Berry, Huff, McDonald, Milligan Inc.
Engineers, Surveyors

August 20, 2014

RE: Level I-Minor Residential Development Review Site Plan Revisions
218 Washington Avenue – Glenn Morse
Application #2014-01234

SECTION **C** S2-1 1"=1'-0

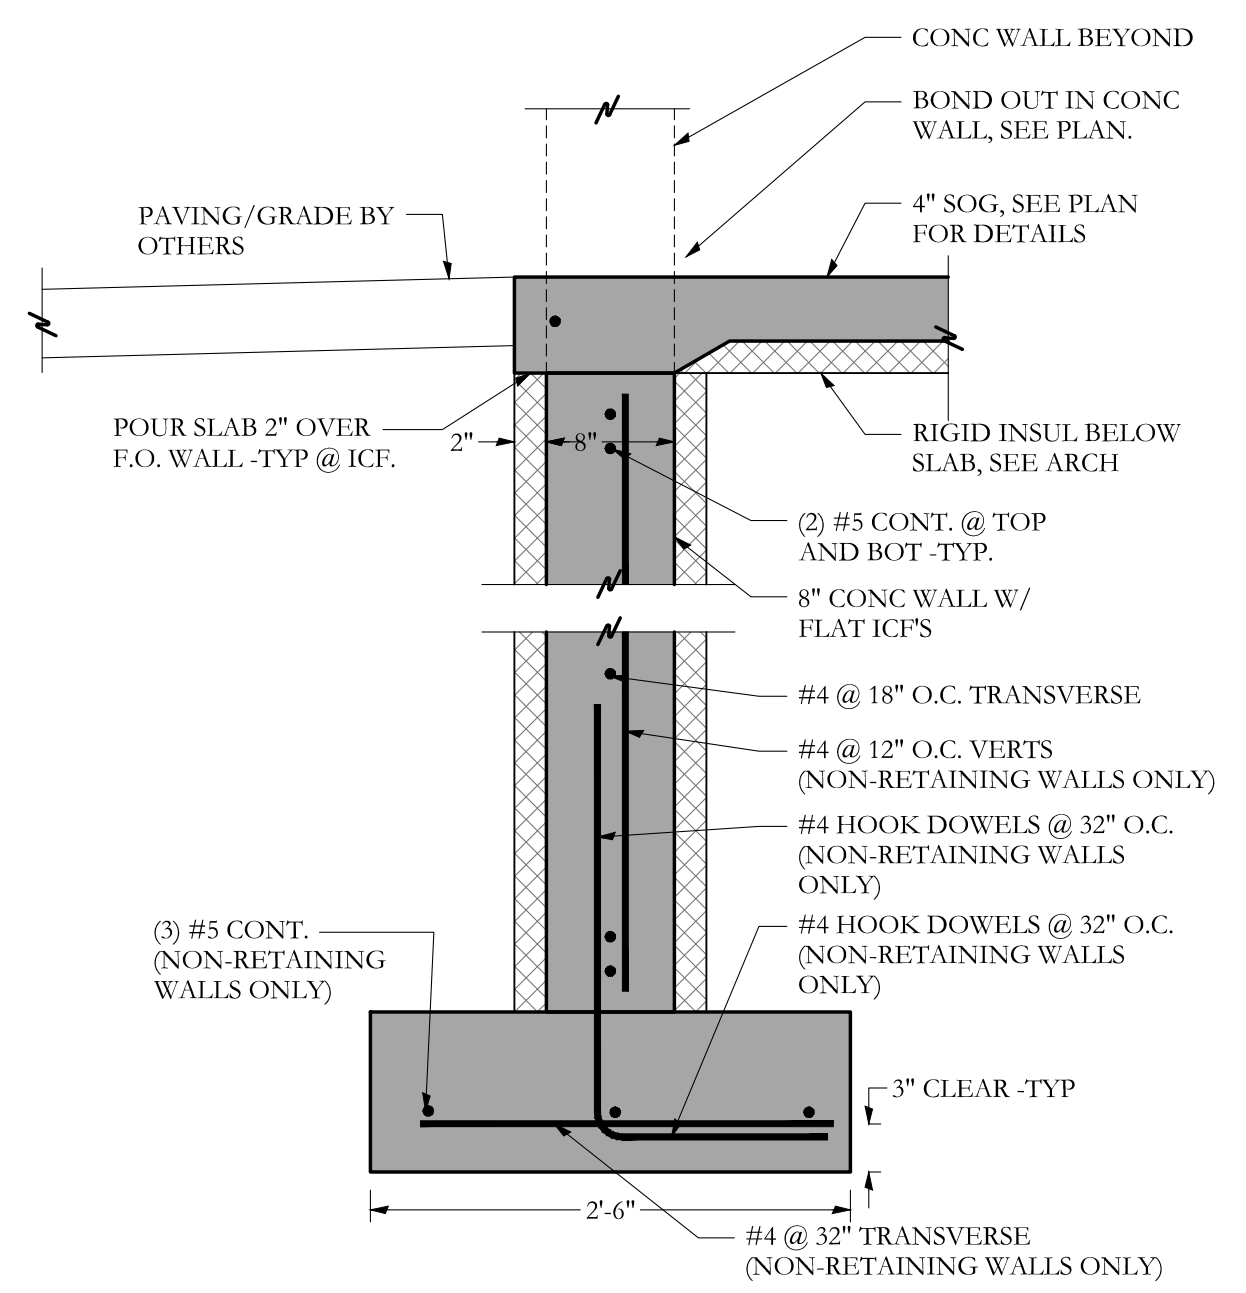
2. A grading and construction easement has been added to the abutting lot along with dimensional requirements for the City to review.
3. The retaining wall on the Northern side of the building is a proposed retaining wall. Please find attached the design by Structural Integrity Consulting Engineers Inc.
